DESCRIPTION: **The Belvedere**

Proposed Residential Flat Building (56 dwellings) with ancillary facilities (office premise and indoor recreation facility), two basement levels for car parking, land amalgamation and strata subdivision; and associated site

NSW Planning Portal (Major Projects) – SSD-83366960

This Crime Prevention Through Environmental Design (CPTED) and Crime Risk Assessment report has been prepared to accompany the Development Application for the Belvedere project, located at 42 Donald Street, 5 and 7 Church Street, Nelson Bay, NSW. The proposal comprises demolition of existing structures, bulk earthworks, construction of a nine-storey residential flat building (56 units and a manager's office), basement parking, and associated landscaping and services works.

Drawing Title
GA Plan - Ground

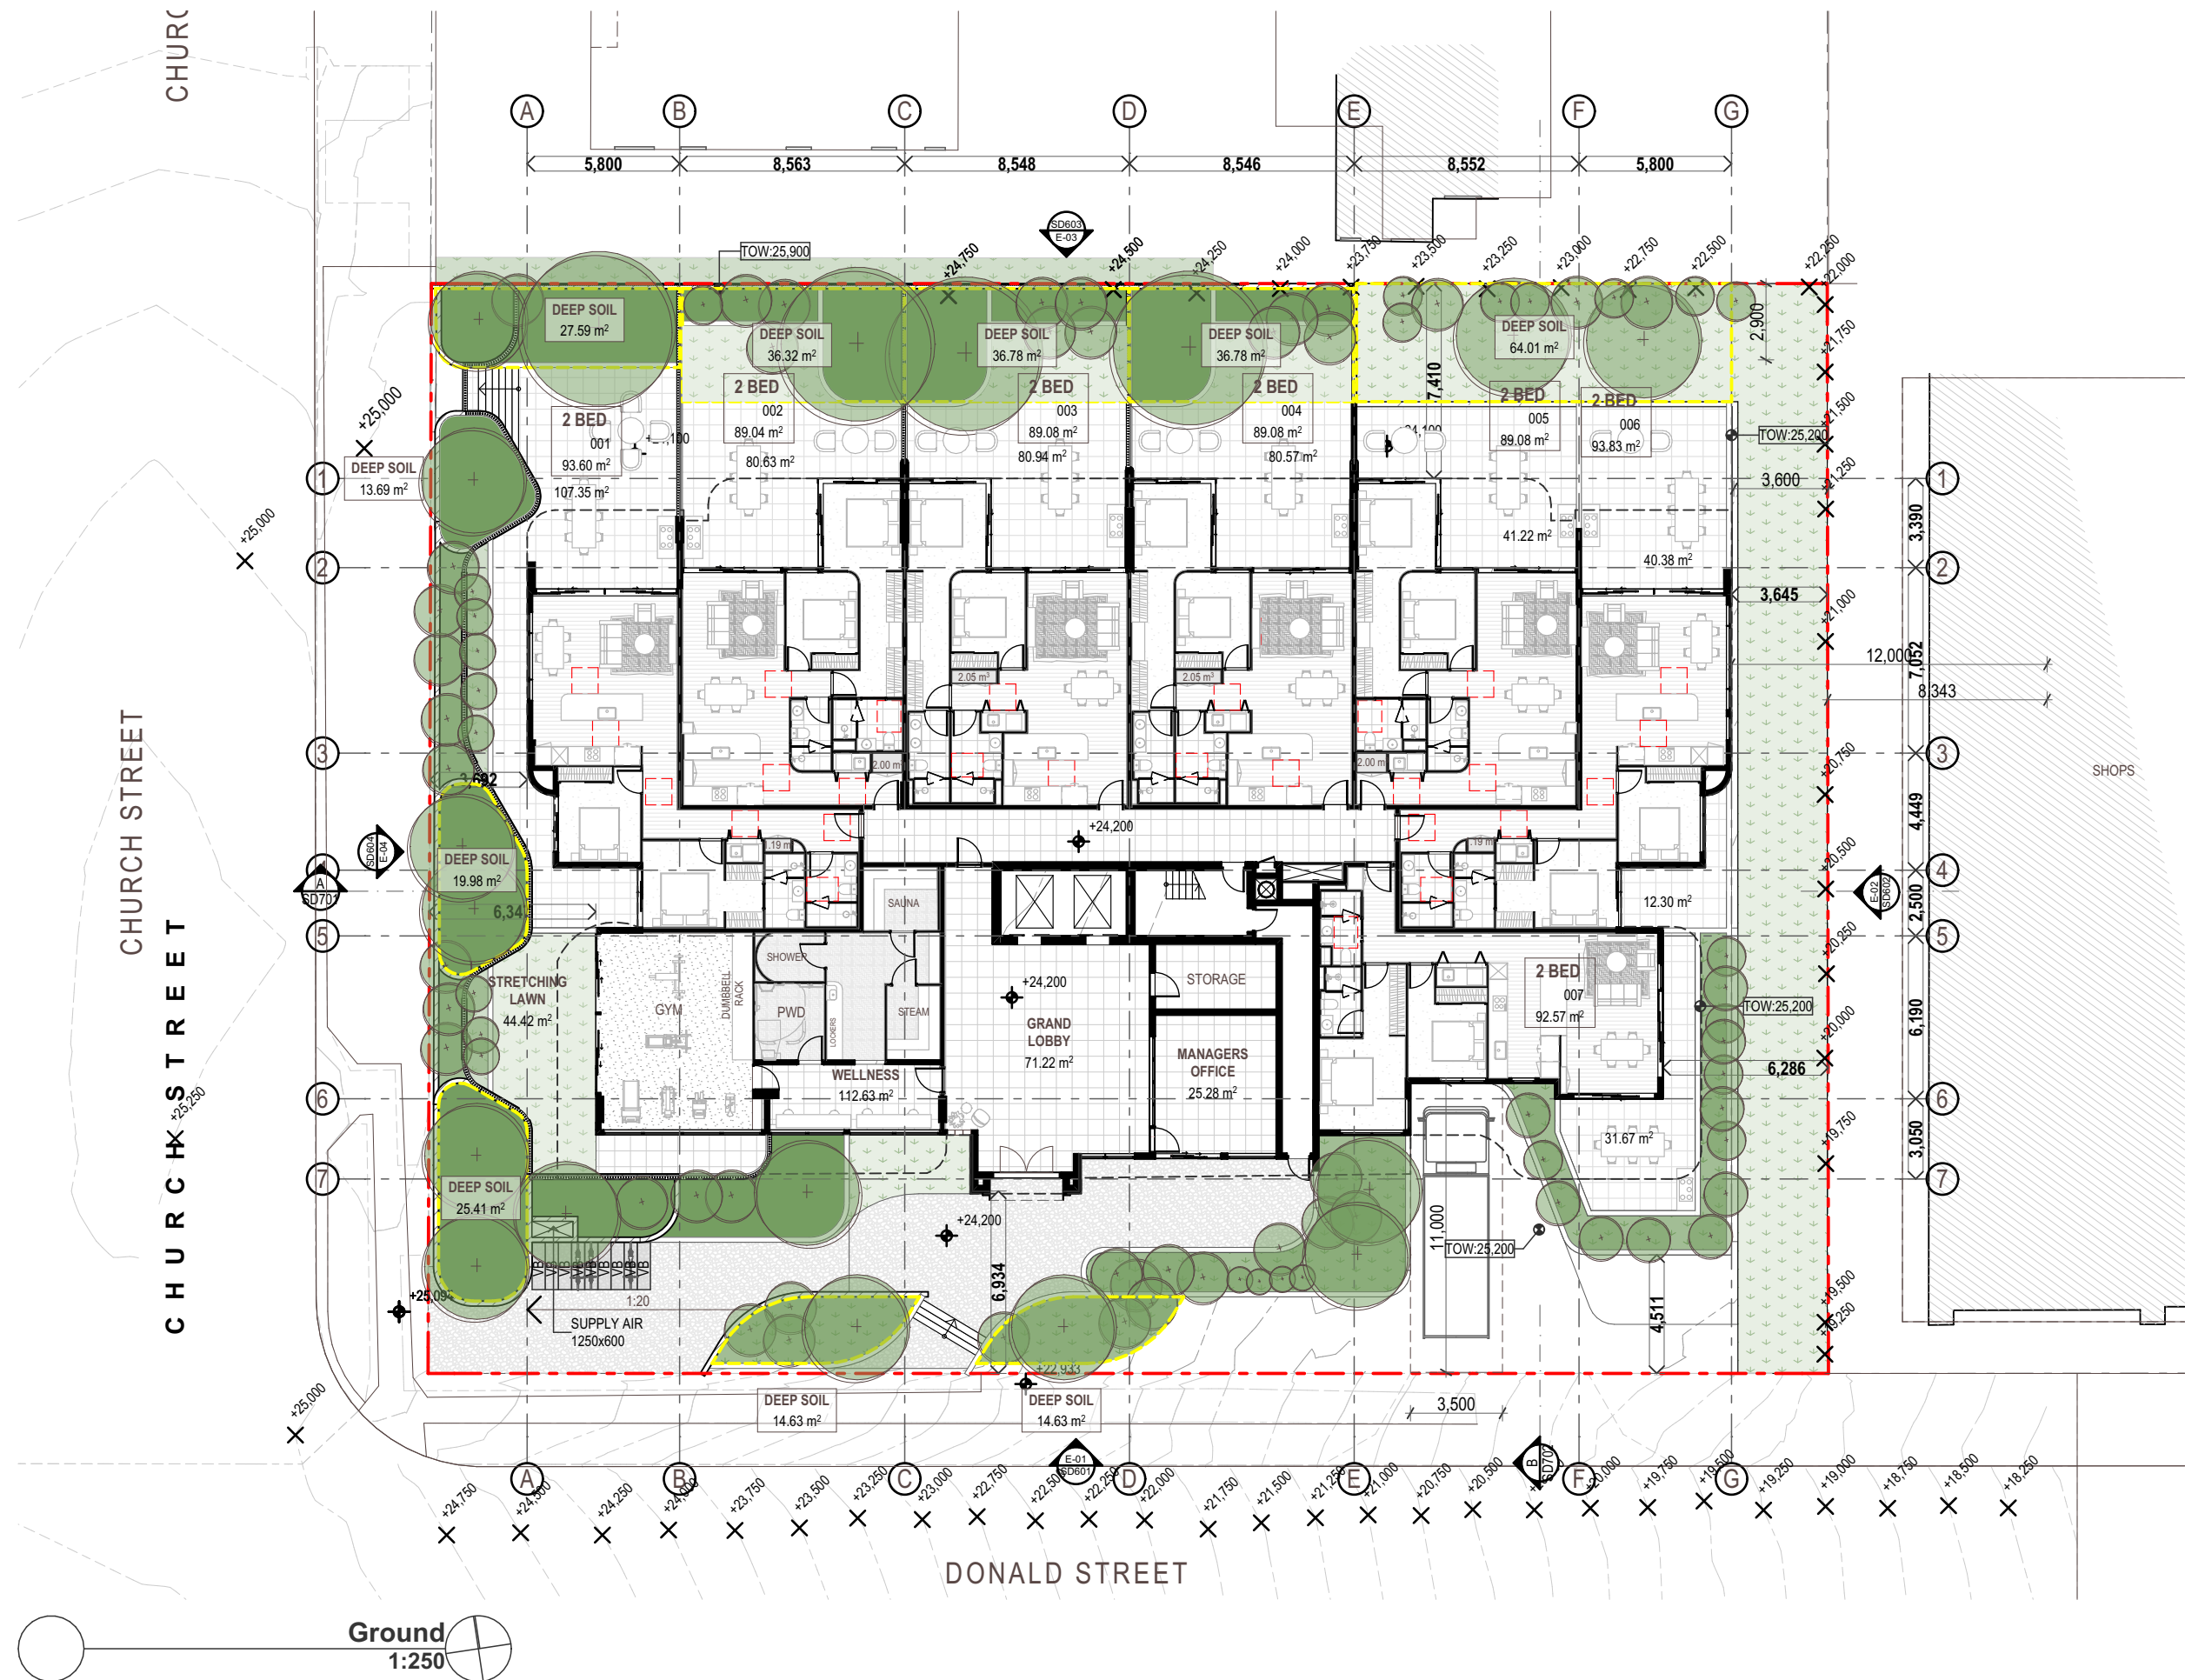
Issue Discussed	Comments
7. Safety <i>The development has the opportunity to improve safety for residents, visitors, workers, service providers and the wider community. As the site is located on the edge of the CBD, it is important that safety is integrated into the design to avoid spaces where antisocial or criminal activity could occur. The goal should be to make it risky and difficult to commit a crime, encouraging offenders to move on.</i> <i>There are several areas for improvement:</i>	
Front Setback: While the streetscape is visually appealing, it is heavily vegetated with layered planting that limits views to and from the street, creating pockets of entrapment and concealment. The Applicant has expressed a desire to create 'enclosed spaces' in both	The layered vegetation has been reduced, and plant species reselected to maintain clear sightlines between 0.6 m and 2.0 m above ground. Planting has been repositioned to remove concealment points and improve visibility between the street, footpaths,

the landscape and built form of the front setback; however, the design must consider all users, particularly women and vulnerable people, who may be at greater risk or feel unsafe in enclosed or hidden areas. These types of spaces can negatively impact perceived and actual safety. The Panel recommends reducing the layering of vegetation (e.g. multiple deep garden beds layered back from the street), and carefully selecting plant species that don't block view lines between the lower branches of trees and the top of ground covers and low shrubs.

The office entry is via a meandering path behind visitor bike racks and landscaping. This area does not relate clearly to the street, making wayfinding difficult for visitors and potentially facilitating excuse-making or loitering. Although the protruding front entry clearly marks the entrance, it also obstructs views of the office and wellness centre façades, especially in combination with the landscaping. Opportunities to simplify the landscape design and reduce walls are encouraged, as excessive walls can be costly and prone to failure, as discussed in other sections. Improving direct visibility and access from the street - by potentially realigning the Donald Street stairs or modifying the Church Street path - should be explored.

The driveway is proposed to be open to the street, which allows direct access to a concealed lift lobby area. This is a high-risk zone for malicious damage, such as graffiti and criminal and anti-social behaviour, such as theft from cars. Particularly as Nelson Bay is a coastal tourism town that experiences seasonal crime and anti-social behaviour. Spaces designed in this way have a stronger reliance on CCTV which is only useful when constantly monitored. Visitor parking is proposed at the same level as resident storage cages, which are vulnerable and should be relocated to the secured, private level below. Storage cages are easy targets.

decisions are not solely to enable building servicing from time to time. During the meeting, there was a discussion about providing a gate deep within the building, around the corner, to separate the visitor carpark from the resident carpark and then leave the visitor carpark open during the day and secured at night. However, if the carpark gate is to be relocated around the corner, care must be taken to ensure this does not worsen concealment or sightline issues, even during the day.

The optimal solution provides a gate between the truck (open air section) and the visitor parking area. This will also secure the lobby access and leave two parking spaces outside the secure line, and these could be retained or removed and used for building services. A second gate could be included internally to separate visitor parking from resident parking. Note that gates should prevent both pedestrian and vehicular access to prevent pedestrian access to the building, storage cages, vehicles and people.

and building entries, consistent with CPTED principles.

The main pedestrian entry has been realigned and widened, bringing the office, residential, and wellness centre entries into a single visible alignment from Donald Street to improve wayfinding. Landscaping, bike rack placement, and levels have been adjusted to enhance direct sightlines from the street, reduce potential loitering areas, and increase casual surveillance.

The revised design addresses Council's CPTED and access control concerns through a two-gate system (Traffic Impact Assessment, QTraffic, Rev C, 19 June 2025, s3.1.2):

- Gate 1 – ~3 m inside the boundary, open by day and closed after hours. Visitors must stop clear of Donald Street, exit their vehicle, and use an intercom for resident authorisation—detering opportunistic entry and enhancing passive surveillance.
- Gate 2 – ~34 m inside, beyond visitor parking and around the bend, separating resident and visitor areas with resident-only swipe/remote access.

- Secures lift lobby and storage cages from street access.
- Blocks unauthorised pedestrian and vehicle entry to private areas.
- Reduces concealment/entrapment risk by locating Gate 2 beyond sightline breaks.
- Maintains safe resident, visitor, and service access.
- This arrangement meets Council's recommended intent while maintaining safety, surveillance, and operational efficiency.
